SUBJECT: Cumberland County, Improvements to SR 1400 (Cliffdale Road)
from US 401 to SR 1403 (Reilly Road); State Work Order
Number 8.2441701; T.I.P. No. U-2520

Subject: Action ID No. 200200640, TIP No. U-2520, SR 1400 (Cliffdale Road) from US 401 to SR 1403 (Reilly Road, Cumberland County, North Carolina.

REDESIGNED INLET AND OUTLET AT CULVERT

Re: Certification Pursuant to Section 401 of the Federal Clean Water Act,
Modification to the Widening and Realignment of SR 1400 (Cliffdale Road) from US 401 to SR
1403 (Reilly Road), Cumberland County, TIP No. U-2520, WQC Project No. 020400, WQC No.
3381

SHEET 9 OF 11  
 8/11/05  
 rev.

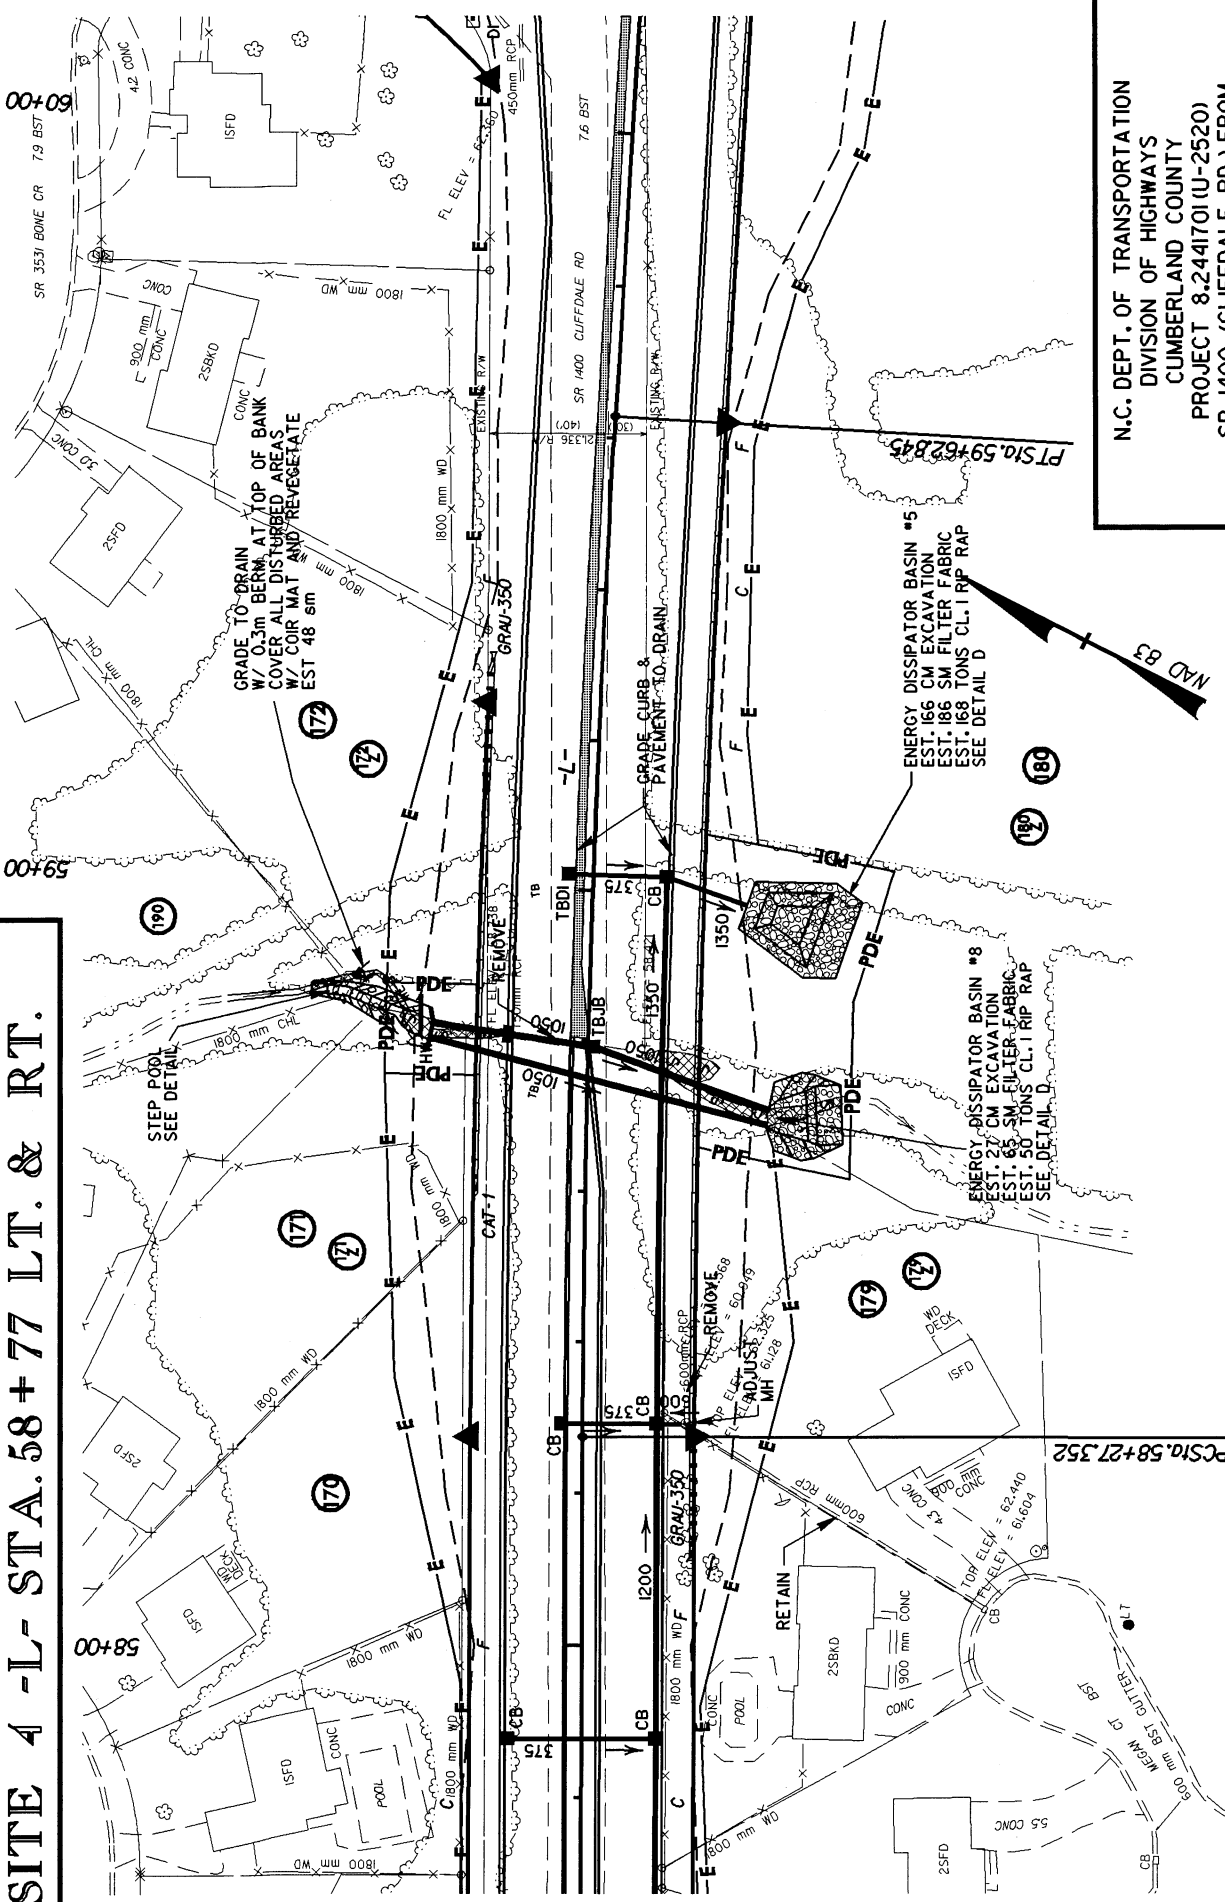
U-2520, permit drawing sheet 9, Station L 58+77, Site 4

The referenced Section 404 permits authorized 92 linear feet of stream impact at this site. Due to culvert misalignment and high discharge velocities the stream is downcutting upstream and downstream. To control the headcutting and provide stability for the stream, a 58 linear foot, step pool control structure is proposed. To control the erosive velocities at the end of the culvert a 35 linear foot rip-rap outlet energy dissipater basin is proposed. This resulted in an increase in impact area of 0.01 acre or 95 linear feet of stream channel.

I have determined that the proposed project modifications described above are not contrary to the public interest and therefore, the DA permit is hereby modified to reflect the modified project as described in the information above and the drawings provided with the modification request.
